# Tween Bridge Solar Farm

## 9.7 Statement of Common Ground with Doncaster East Internal Drainage Board

**Document Reference: 9.7**

**Revision 1**

Figure 2.9: Indicative Layout and Cross Section Plans
Drawing Ref: Typical Culvert Crossing

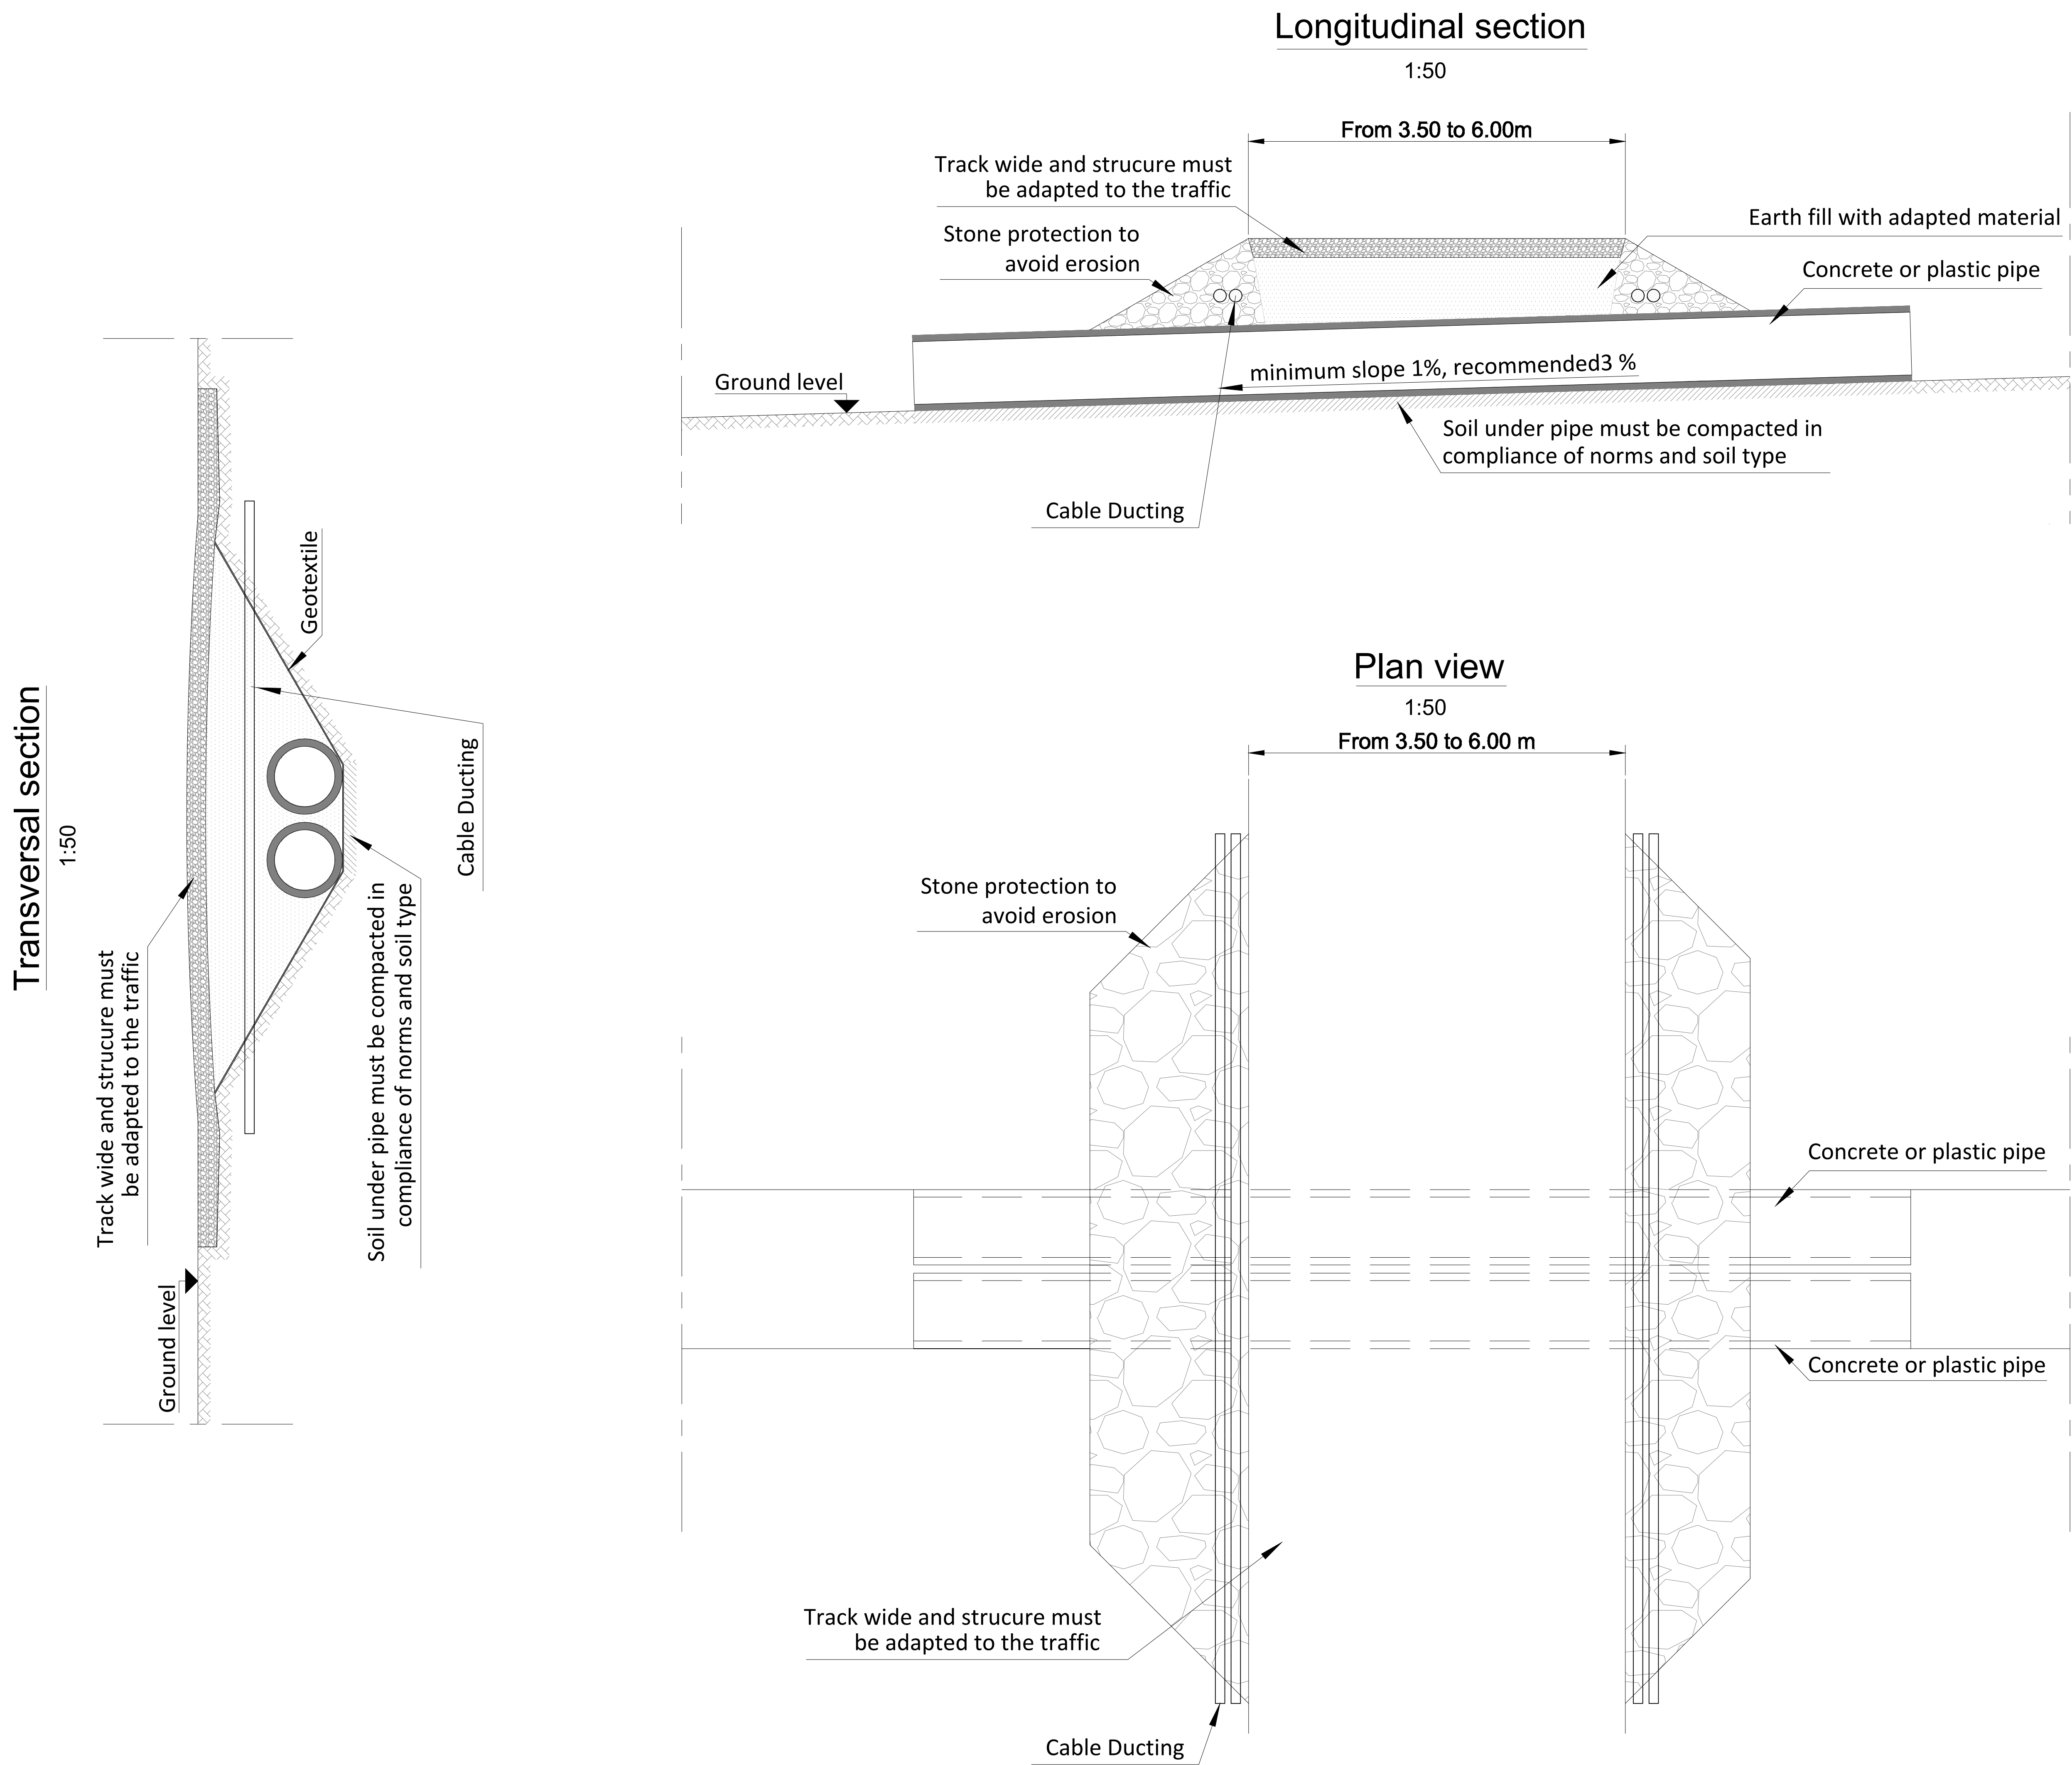
<b>draft DCO [Document References 3.1 Revision 3]</b>	
5.	Culverting/Other Works	Any culverting or other works within the bed of any riparian watercourse within the Board's district or extended area, be they temporary or permanent will also require consent.	<p>The Applicant agrees to provide details of the culverting during the detailed design stage once the <b>draft DCO [[Document References 3.1 Revision 3]</b> is made. Further discussions will be held with Doncaster East IDB.</p> <p>The Applicant draws attention to paragraph 19(1) and (2) of the Protective Provisions in the <b>draft DCO [Document References 3.1 Revision 3]</b> which provide Doncaster East with approval power over plans for the construction of any specified works.</p>	Under Discussion

Non-Intrusive Cable Crossing – Watercourse/IDB Drain/Main River/Canal

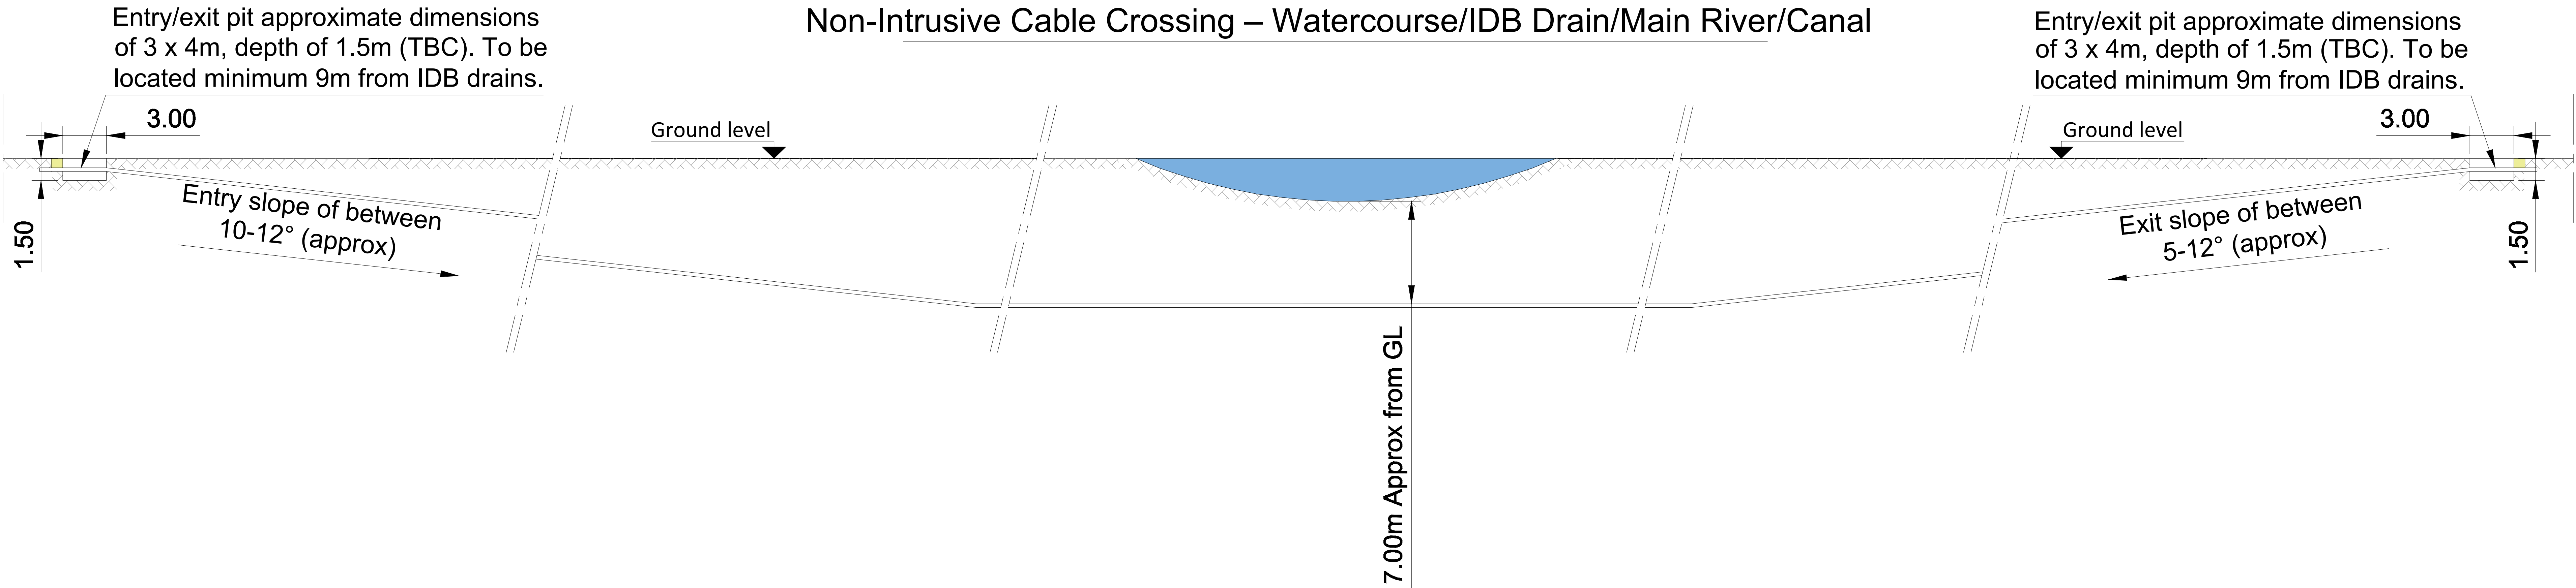
<p>(d) erect or construct or cause or permit to be erected or constructed any fence, post, pylon, wall, wharf, jetty, pier, quay, bridge, loading stage, piling, groyne, revetment or any other building or structure whatsoever in, over or across any watercourse or in or on any bank thereof;</p> <p>(e) place or fix or cause or permit to be placed or fixed any engine or mechanical contrivance whatsoever in, under or over any watercourse or in, over or on any bank of any watercourse in such a manner or for such length of time as to cause damage to the watercourse or banks thereof or obstruct the flow of water in, into or out of such watercourse.</p> <p>Provided that this Byelaw shall not apply to any temporary work executed in an emergency but a person executing any work so excepted shall, as soon as practicable, inform the Board in writing of the execution and of the circumstances in which it was executed and comply with any reasonable directions the Board may give with regard thereto.</p> <p>The Board will require all watercourses to be crossed by means of an appropriate trenchless method at a depth no less than 2 metres PLUS the safe working distance below</p>

<p>the hard bed level of all watercourses (to ODN if EA or IDB maintained). The purpose of this requirement is to allow the IDB to maintain and have the flexibility to improve watercourses in the future due to climate change (works will include deepening &amp; widening of watercourses).</p> <p>Any culverting or other works within the bed of any Board maintained watercourse be they temporary or permanent will require consent. It will usually be assumed that these structures will be temporary measures to accommodate haul roads etc.</p>
